Our ref: DOC22/28890

Your ref: SSD-7401 MOD 3

Subject: EES comments on Environmental Assessment for the Modification Application for Bettergrow Resource Recovery Facility - MOD 3 amendment to weighbridges, carparking and stormwater– SSD-7401-MOD 3 – 24 Davis Road, Wetherill Park

Figure 4 | Proposed Site Plan at Ground Level (DA004 Issue D) SSD-7401-Mod-3

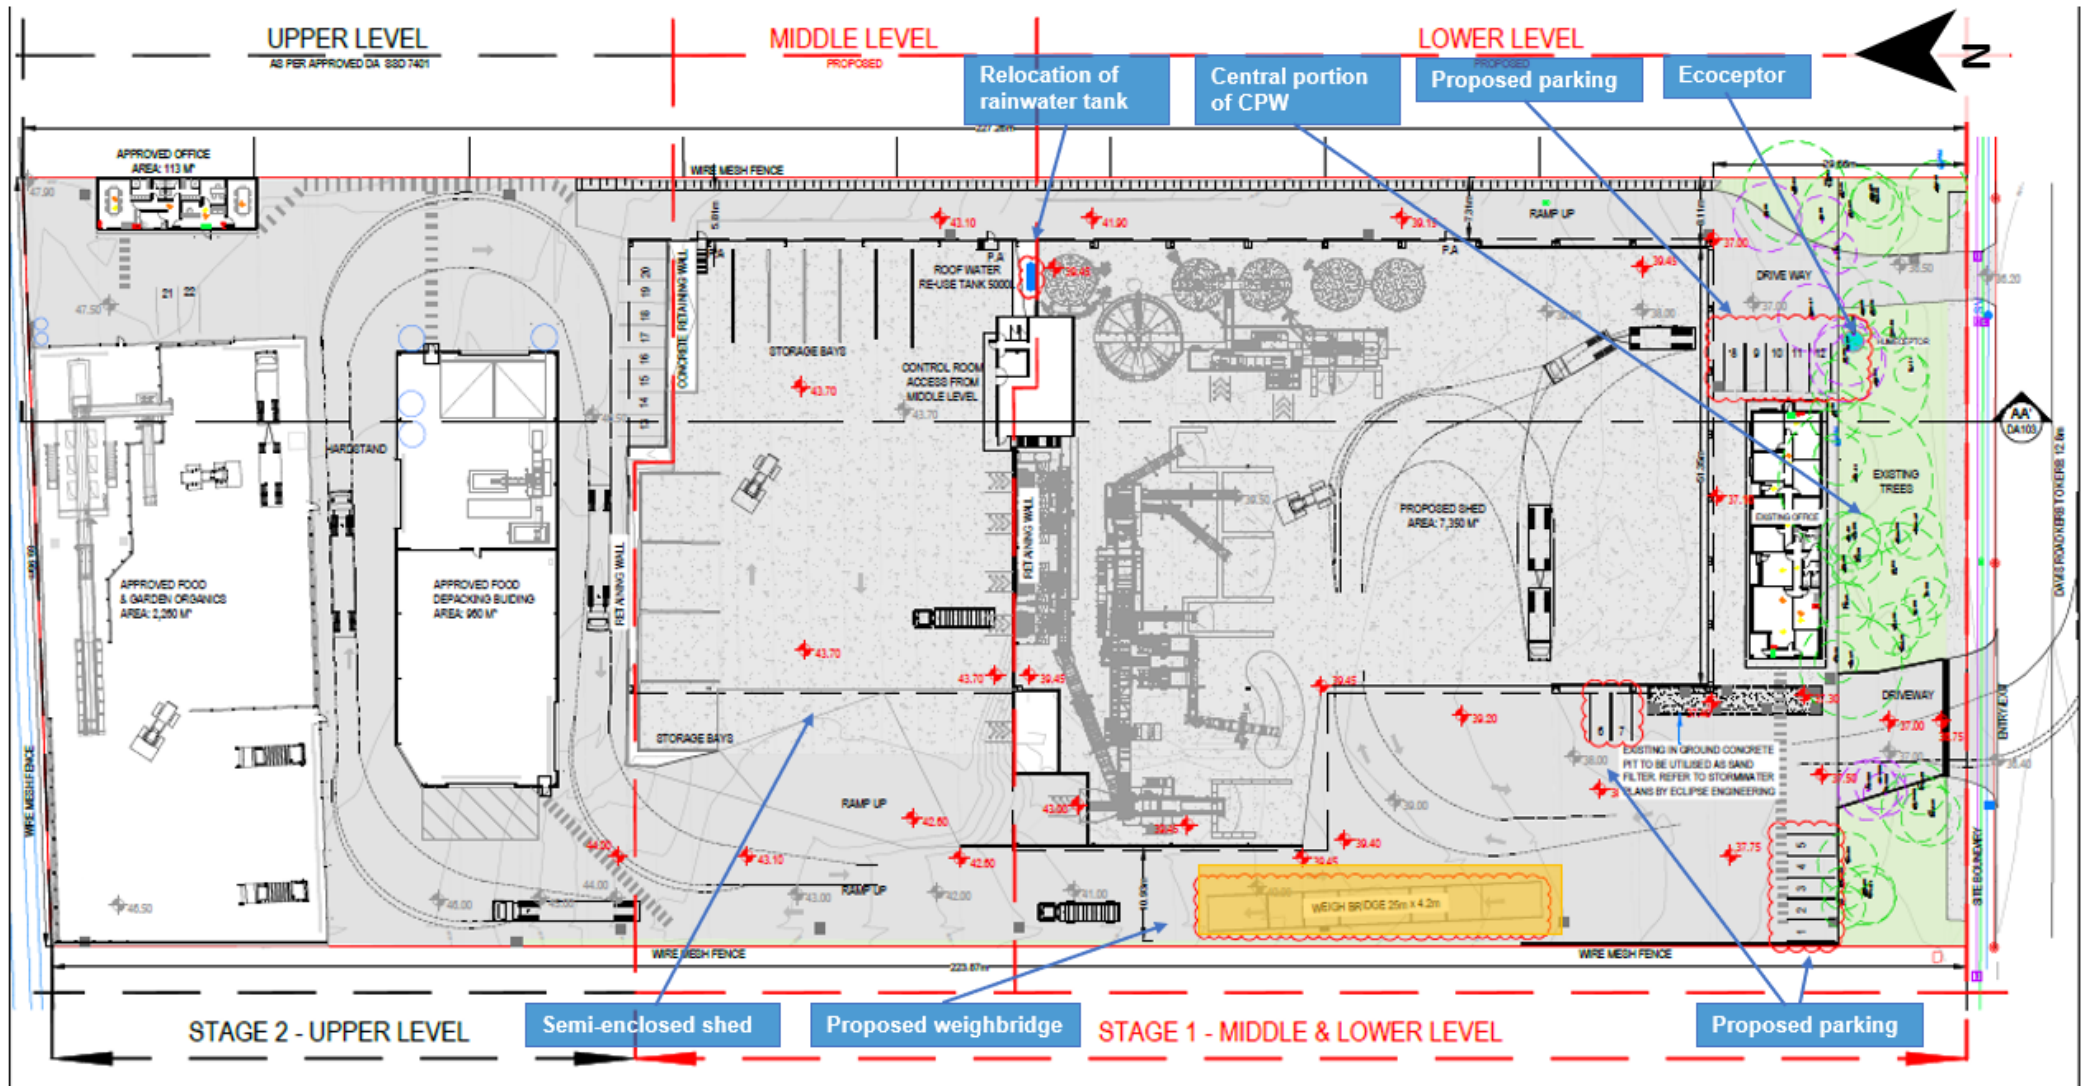
It is unclear which proposed carparking spaces require the removal of the CPW which Section 5.1 of the EA indicates will need to occur to facilitate the installation of parking spaces. The RtS needs provide details on this. For example, it is unclear if:

- the five carpark spaces noted in point (a) above which are proposed to be located immediately east of the existing site office will impact remnant native vegetation. Figure 4 shows the proposed carpark is near the CPW, or if
- the carpark noted in point (c) above will require any removal of CPW. Figure 4 shows the proposed carpark is located immediately to the north of the CPW.

If the proposed carpark spaces noted in point (a) will impact CPW, EES queries why the car park spaces can't be located along the southern boundary of the site building (see blue arrow in Figure 4 below). The RtS should provide details on this.

The MOD 3 proposes five parking spaces (as noted in point (c) above) which are to be located on the hardstand area immediately north of the western parcel of retained CPW (as shown on Figure 4 of the EA (see below). EES queries why these five parking spaces can't be located next to the proposed two parking spaces (as note in point (b) above) which are proposed to be located north of the inground sand filter, abutting the western façade of the drill muds processing shed (see red arrow on Figure 4 below) particularly as the proposed five car parking spaces adjoin the retained CPW. The EA indicates the site slopes from north to south so runoff from the carpark has the potential to enter CPW unless adequate mitigation measures are in place. Relocating the five carpark spaces to adjoin the proposed two parking spaces would prevent earthworks and sediment runoff associated with the carpark construction and surface runoff during operation of the carpark from being immediately adjacent to the CPW.

Section 5.1 of the EA states "The proposed modification has been designed so that only vegetation on the fringes of CEEC Cumberland Plain Woodland is impacted" It is unclear if the proposed replacement 25m by 4.2m weighbridge (which is to replace the five (5) approved weighbridges with one (1)) will impact any CPW. The RtS should clarify this. If so, EES queries why the proposed replacement 25m by 4.2m weighbridge (which is to replace the five (5) approved weighbridges with one (1)) can't be located further north on the road where a truck is shown on Figure 4 so it won't interfere with the CPW (see yellow arrow on figure 4 below).
